## Office of Environment & Heritage

Our Ref: DOC16/527443  
Your Ref: MP 06\_0316 MOD 5

**Re: Modification application to Project Approval - Cobaki Lakes Residential Community Development (MP 08\_0200 MOD 5)**

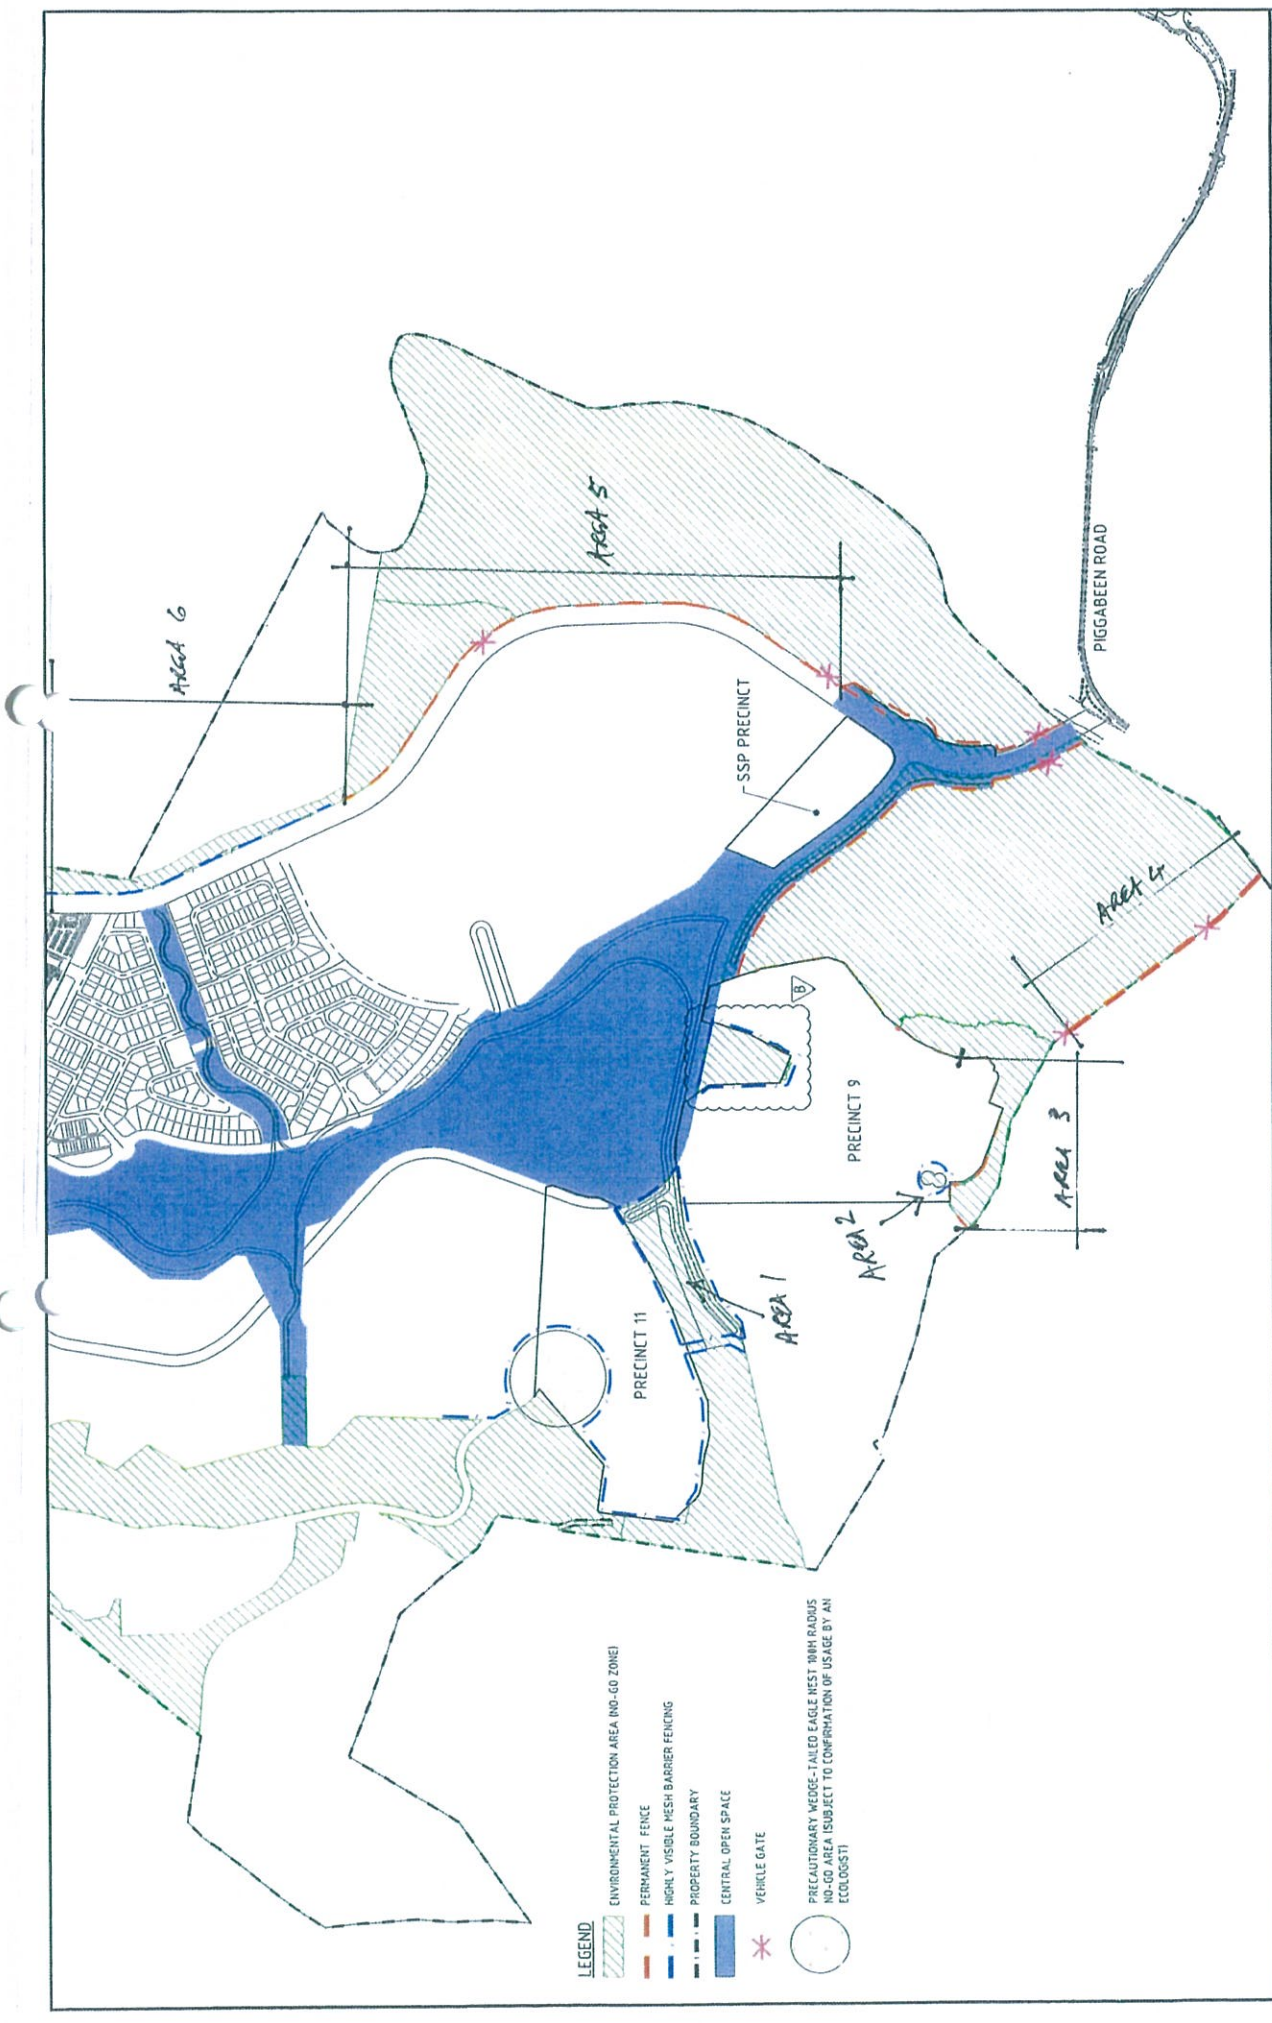
- a. The changes proposed relate to the deletion of fencing in areas designated for future environmental rehabilitation that are currently mapped as '*low closed grassland with scattered trees*'. Some of these areas form part of an Endangered Ecological Community and although are in a degraded condition should still be afforded fencing for protection. The fencing will provide a better surety that accidental intrusion into these areas is reduced. The fencing will also enable the site to naturally regenerate that will provide a biodiversity benefit and reduce the costs of rehabilitation, which is planned for these areas in the future.

- c. The OEH notes that the tree containing the raptor nest was felled by an unknown person in December 2015. The installation of fencing may also reduce incidents of unknown persons entering these areas and causing environmental harm.

- d. The OEH notes that the site is regularly trespassed by off-road bikers. This provides additional justification to ensure that adequate fencing is installed to deter intruders from areas identified for protection and/or rehabilitation.
- e. A letter by SMEC dated 6/5/2016 suggests that the proposed revegetation areas, 'on their analysis, [are] not of significance, other than in respect of any areas of established trees and shrubs'. There appears to be a significance threshold being used to determine which areas should/shouldn't be fenced. The OEH would put forward that any areas proposed for protection and/or rehabilitation should be fenced regardless of their condition state.

The OEH does not support any proposal to reduce or delay fencing associated with areas proposed for protection and/or rehabilitation and recommends that:

1. The modification proposal should be refused by the Department of Planning and Environment.
2. The slashing of areas proposed for protection and/or rehabilitation should cease immediately.
3. The compliance of the slashing with existing major project development approvals should be investigated by the Department of Planning and Environment.
4. Any impacts to biodiversity either by an unknown person, intruders or accidental incidents should be rectified by replanting and/or rehabilitation of the damaged areas.
